PLANNING DEPARTMENT – Development & Building Services

December 5, 2013

RE: **Shepherd Lutheran Church – 3900 Wyoming Blvd. NE** File # **G20/D036**
Grading & Drainage Plan for Building Permit PE Stamp: **11/01/13**

SHEPHERD LUTHERAN CHURCH 3900 WYOMING BOULEVARD GRADING AND DRAINAGE PLAN		DRAWN BY WCHW DATE 02-13
			JOB # 21325

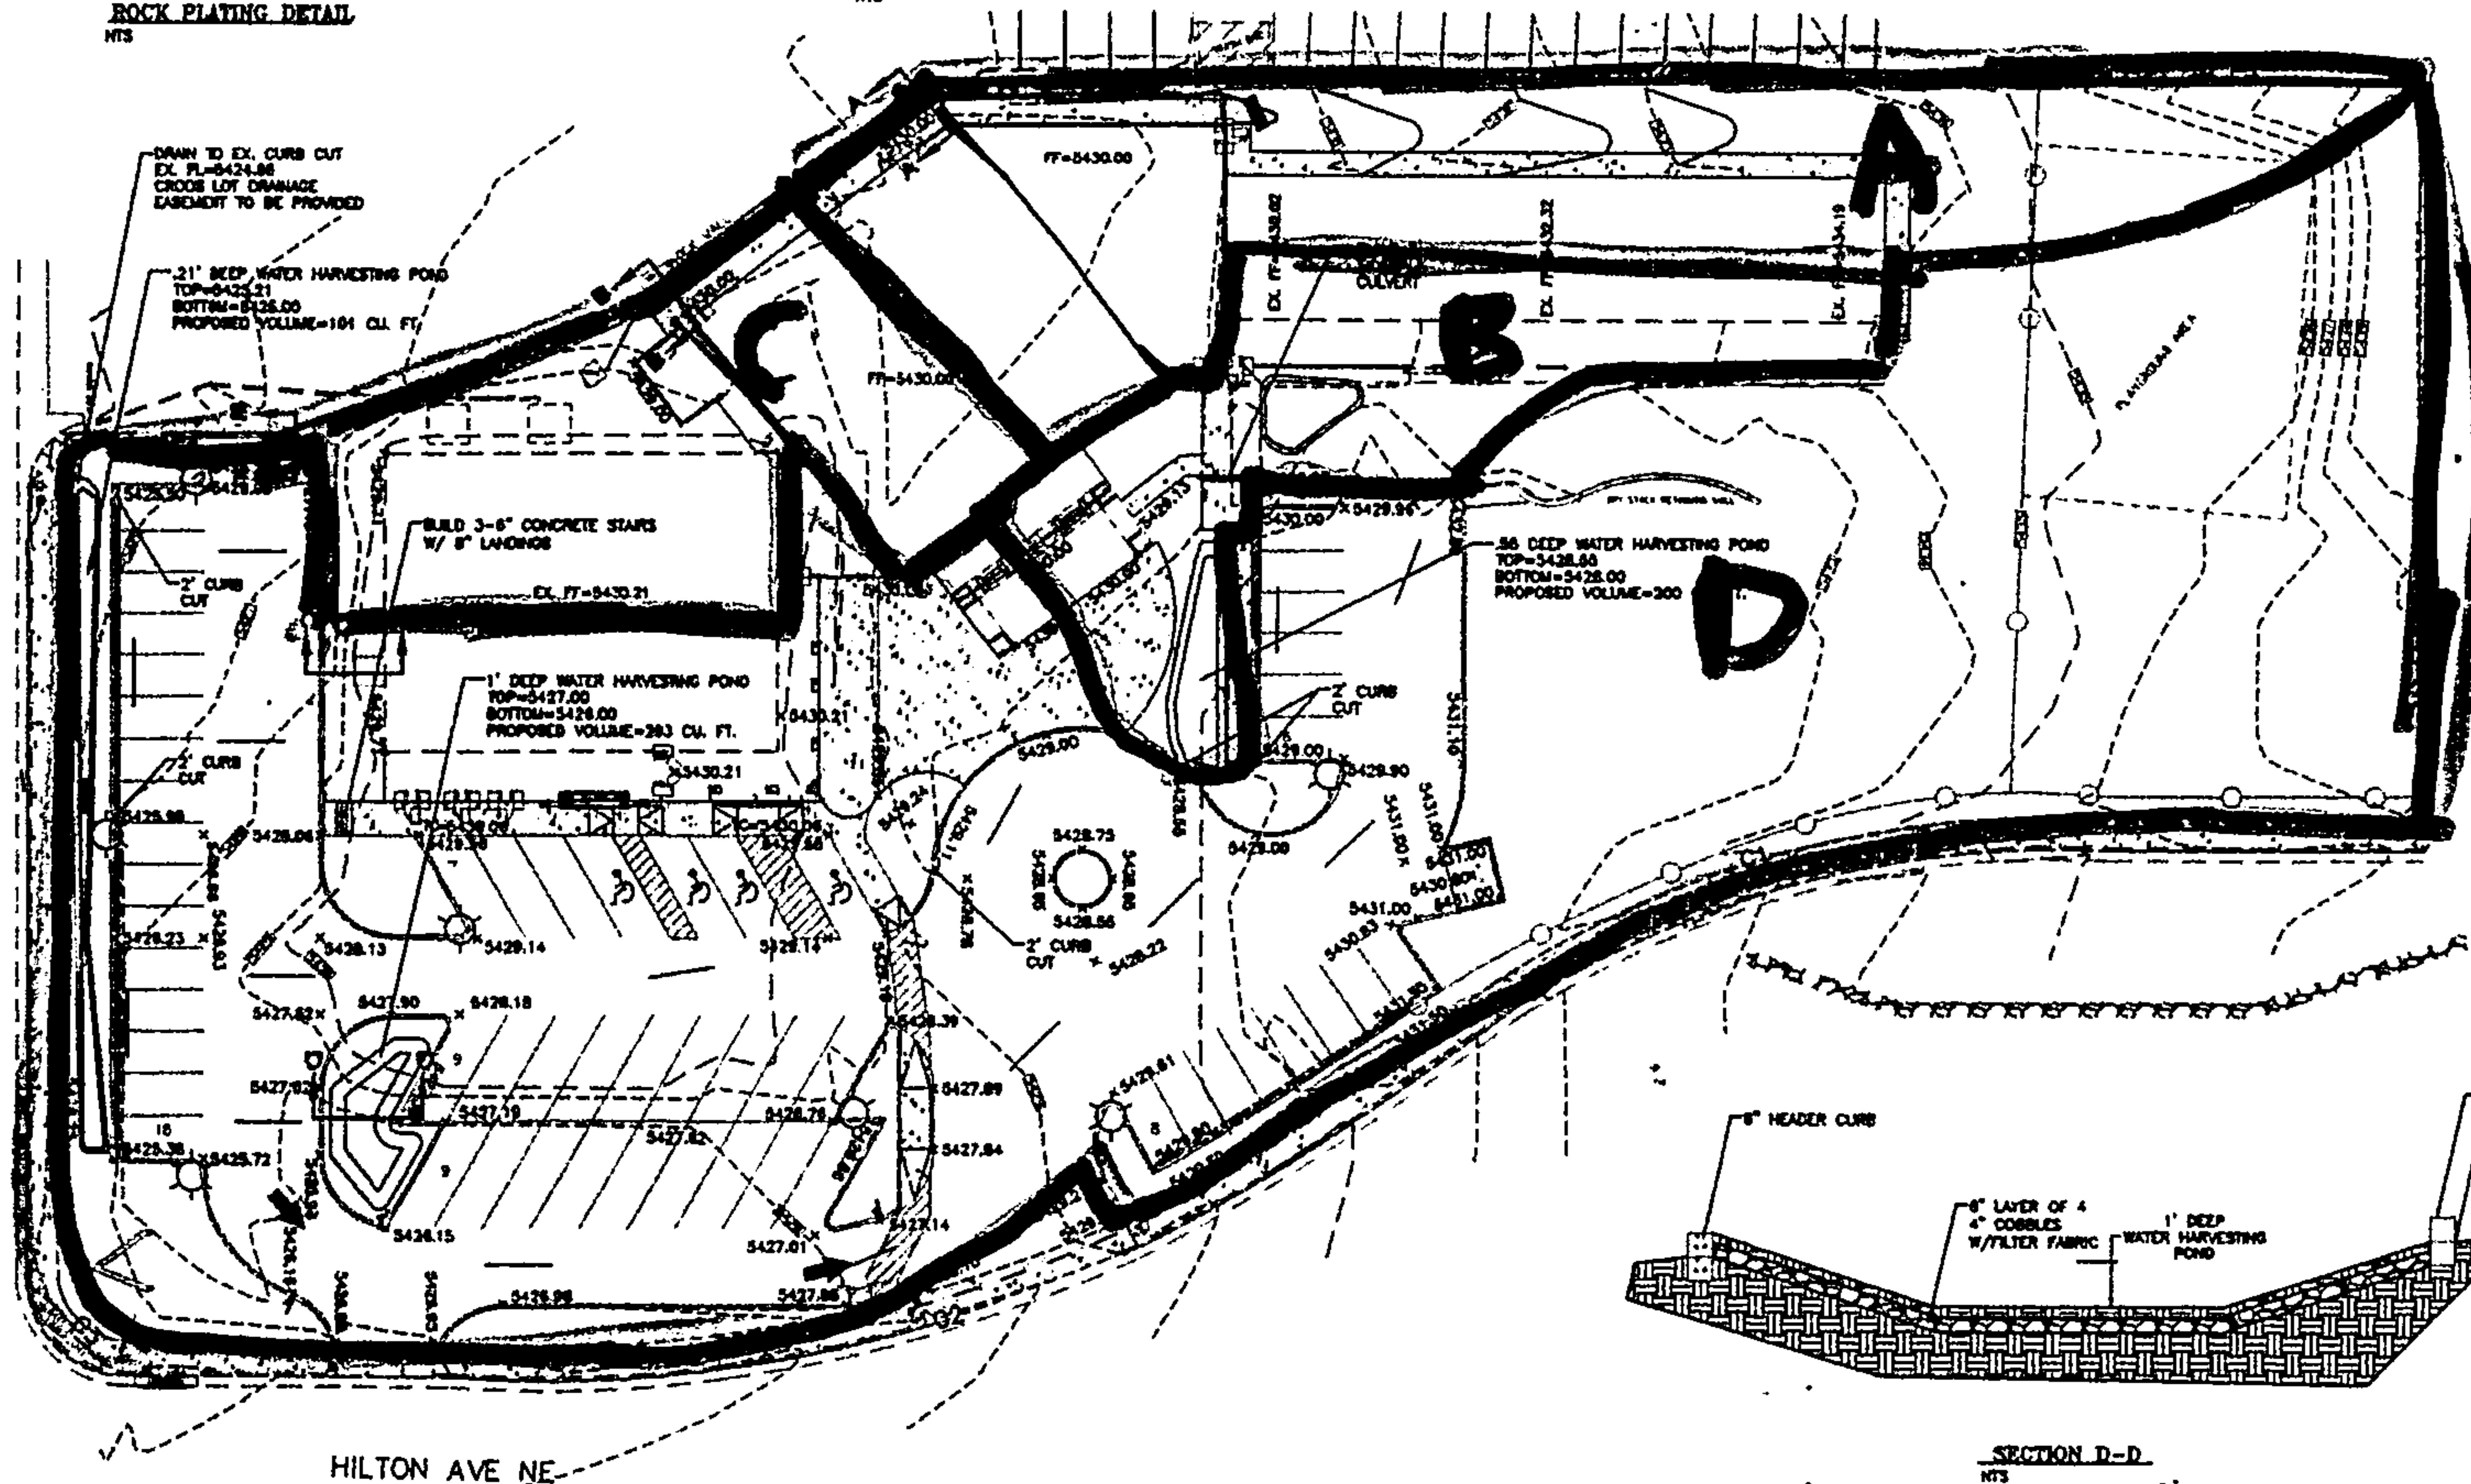
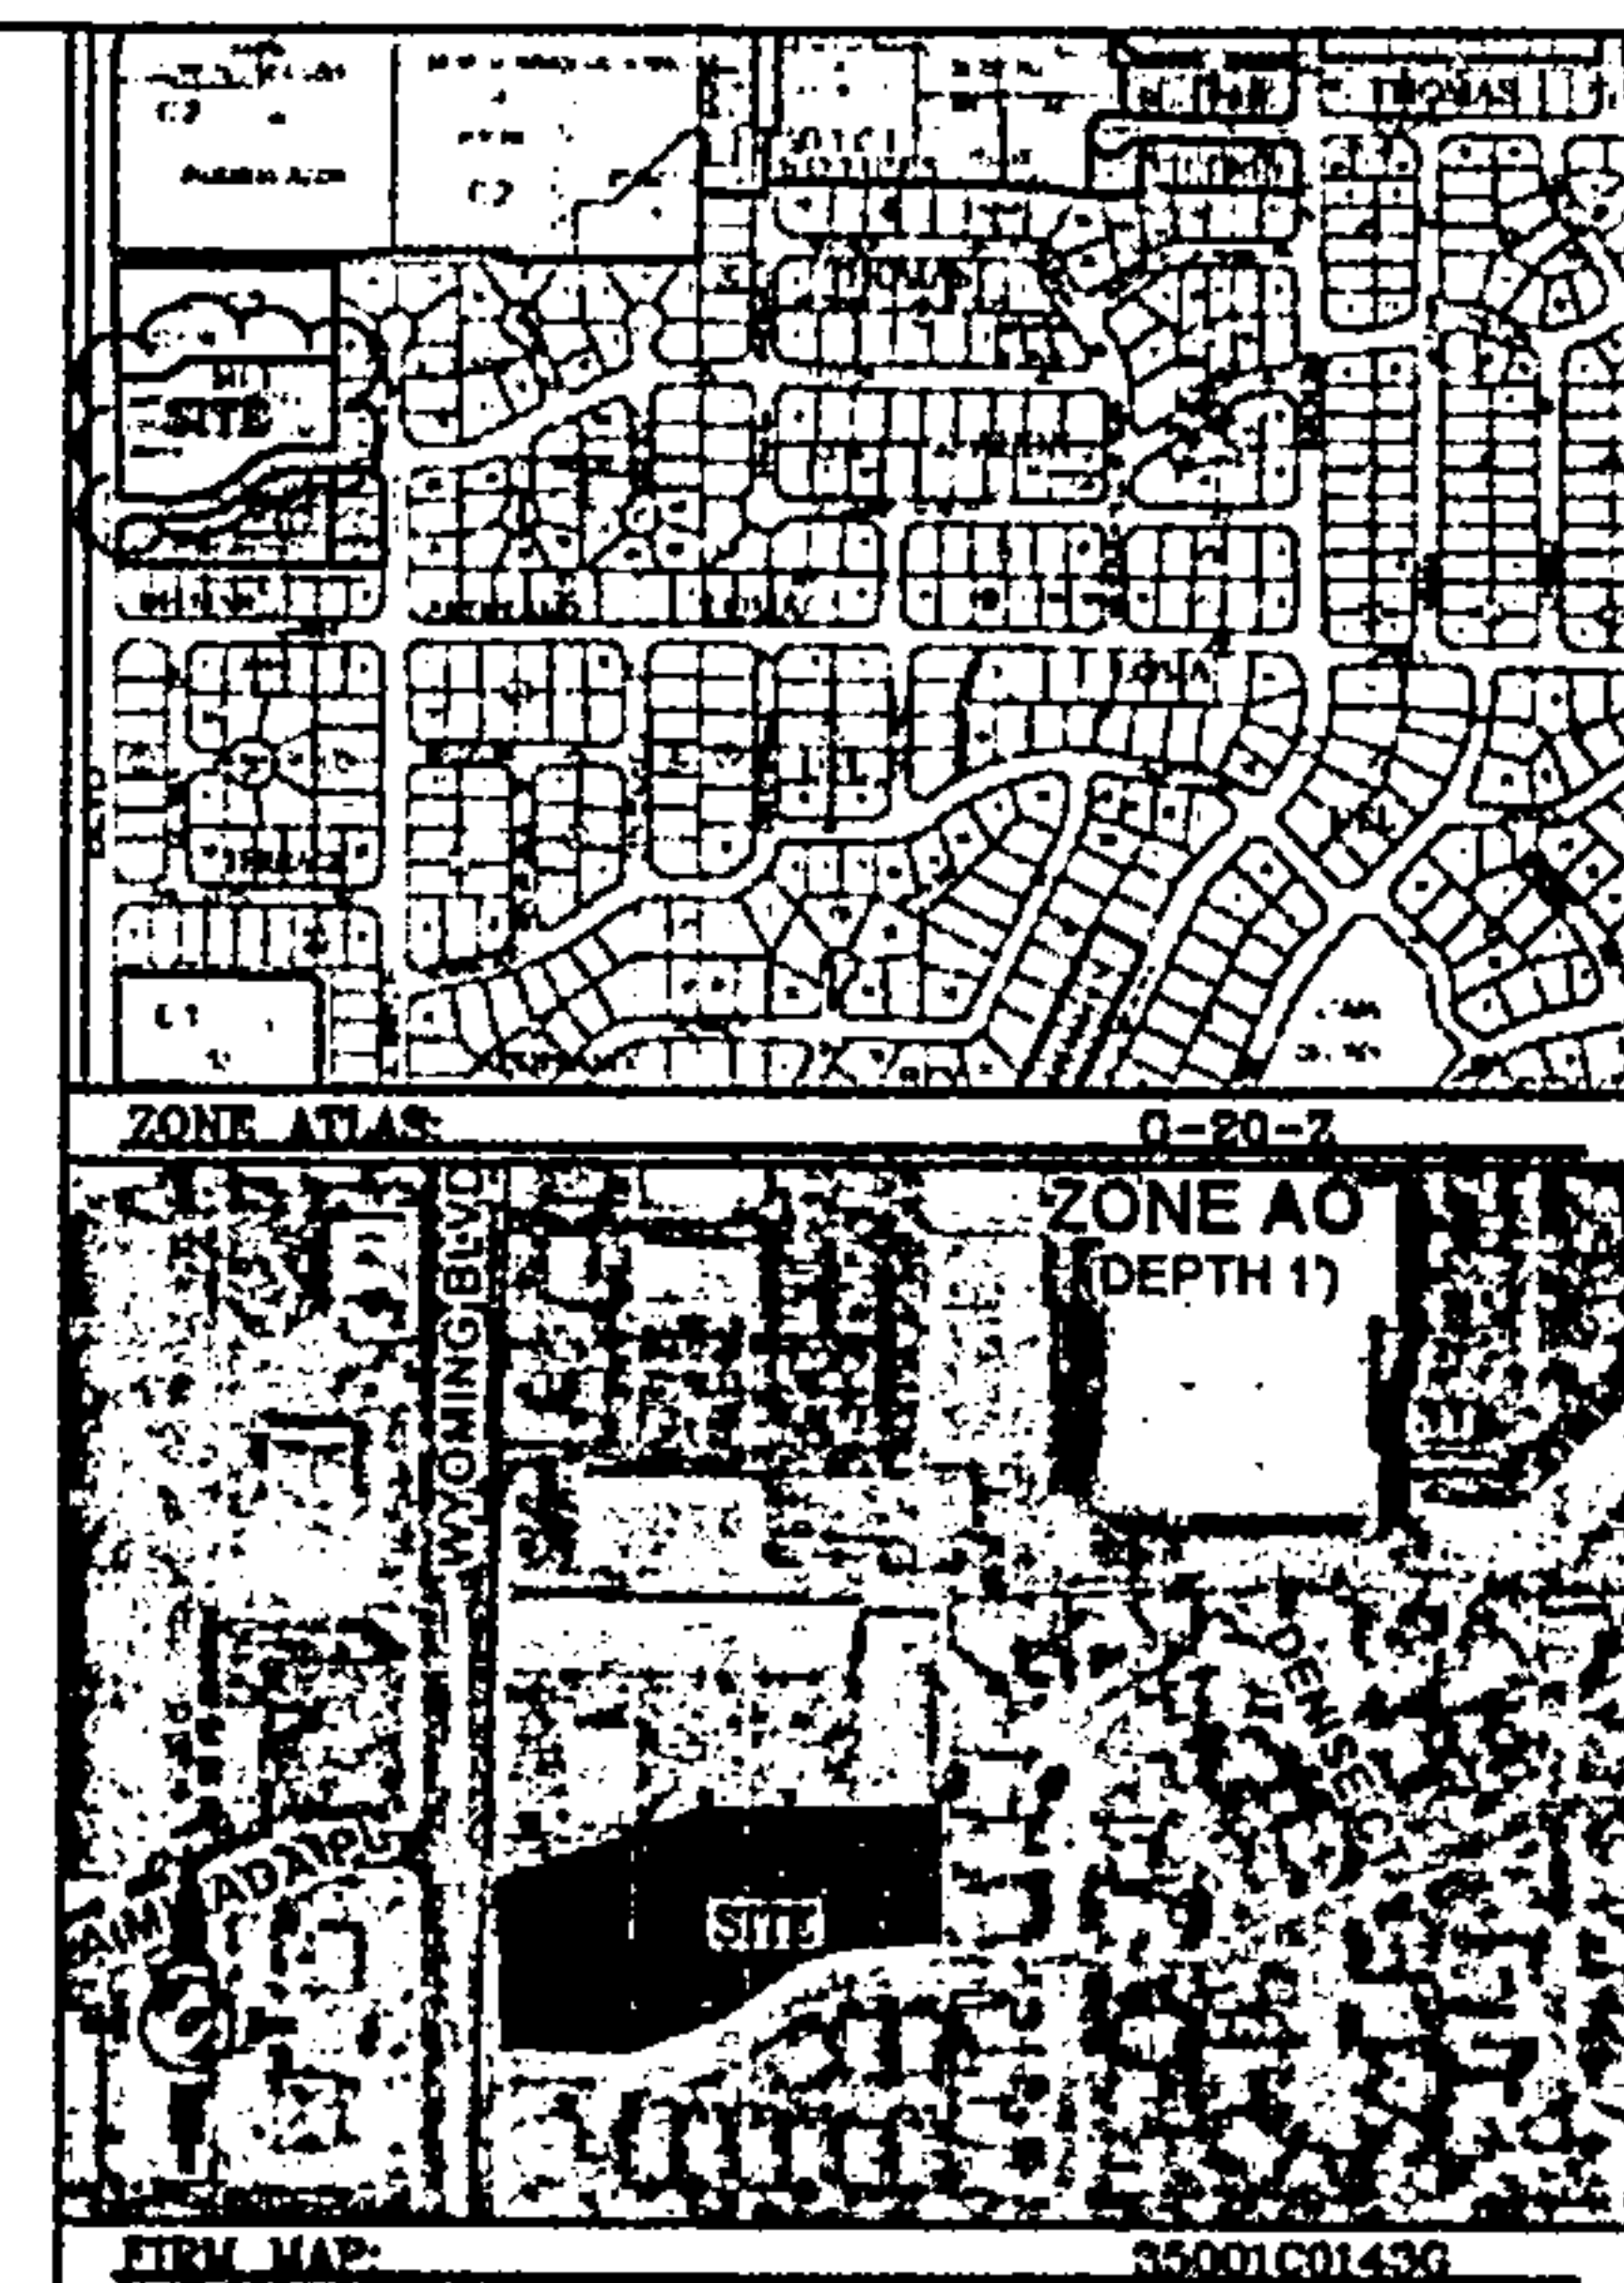
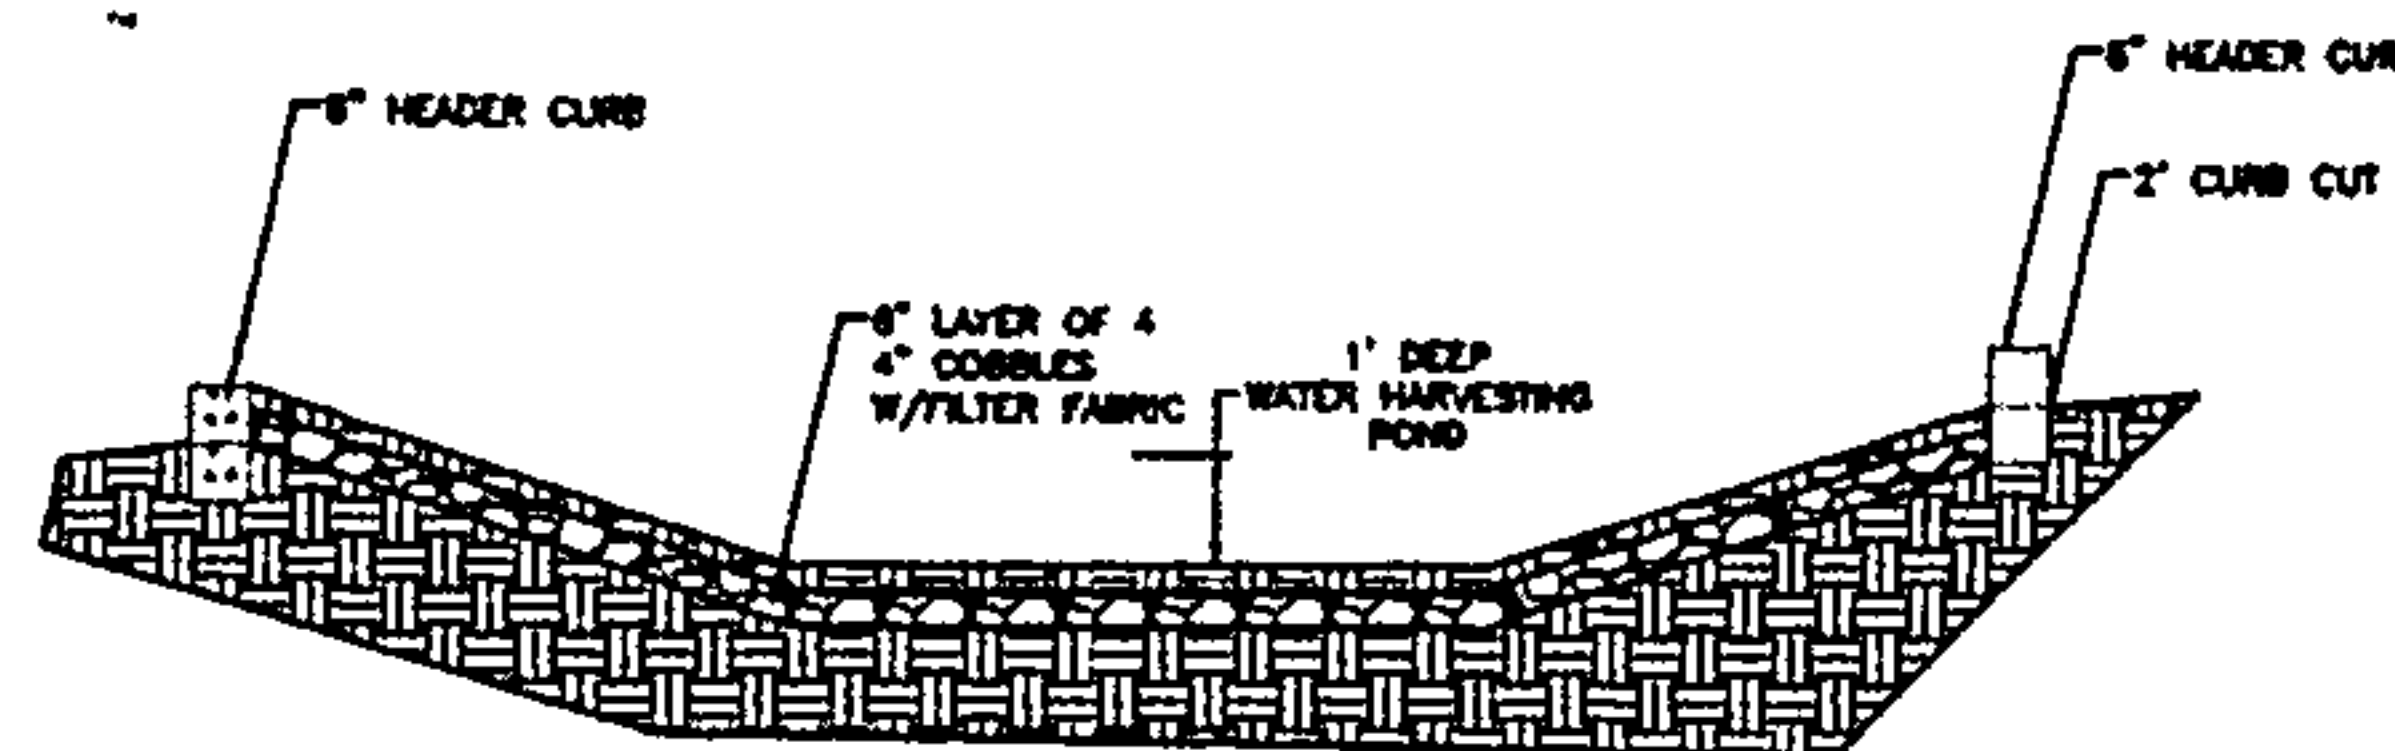
1. Show property boundaries and easements on the Grading Plan.
2. Provide existing grades on the adjacent streets, particularly at driveways to Hilton and near the curb cut discharge point at the NW corner of the site.

3. Historic drainage patterns routed approximately 25% of site flows out the westerly driveway, to an inlet on Hilton Place. This proposed plan diverts all of the flow to the NW corner of the site and expands a 2' curb cut to 9-feet wide. This amount of discharge to that driveway opening is not acceptable. Options to consider include:

- a. Divert some of the site flow to the inlets on Hilton.
 - b. Provide a direct connection to the back of the inlet on Wyoming, via an SO-19, private storm drain connection.

- c. Provide more defined grading to "Detention Ponds" on site to reduce the discharge rate.
4. Update the drainage basin map to include flow arrows and indicate discharge points. Inclusion of an existing basin map would be help to illustrate proposed changes.

5. Show the existing inlet location on Wyoming, and the second inlet on Hilton, between the driveways.
6. The Grading Plan does not include Proposed Contours for much of the site. Spot elevations provided do not clearly demonstrate intended flow patterns, and some such as the eastern parking area appear incorrect.

7. Clarify grades around parking areas; e.g.-sidewalk grades vs. pavement grades. Provide flow arrows and Proposed Contours to clarify flow patterns.
8. Grades provided do not clearly show how runoff will be directed to the Harvesting Pond in the southern parking area. Most flows appear to bypass the curb cut.
9. Flat grades around the Dumpster Pad with 0.2' depression at center will not drain.
10. Provide more detail of the pond along Wyoming. It appears from information provided that runoff will sheet flow over the sidewalk or wheelchair ramp, instead of discharging to the curb cut at the north end. Consider a Private Storm Drain connection to the inlet, per note 3.b above.
11. The plan shows a pipe on the north side of the existing building, with no size or slope information. Confirm capacity for the proposed flows between the existing garden wall and AC units.
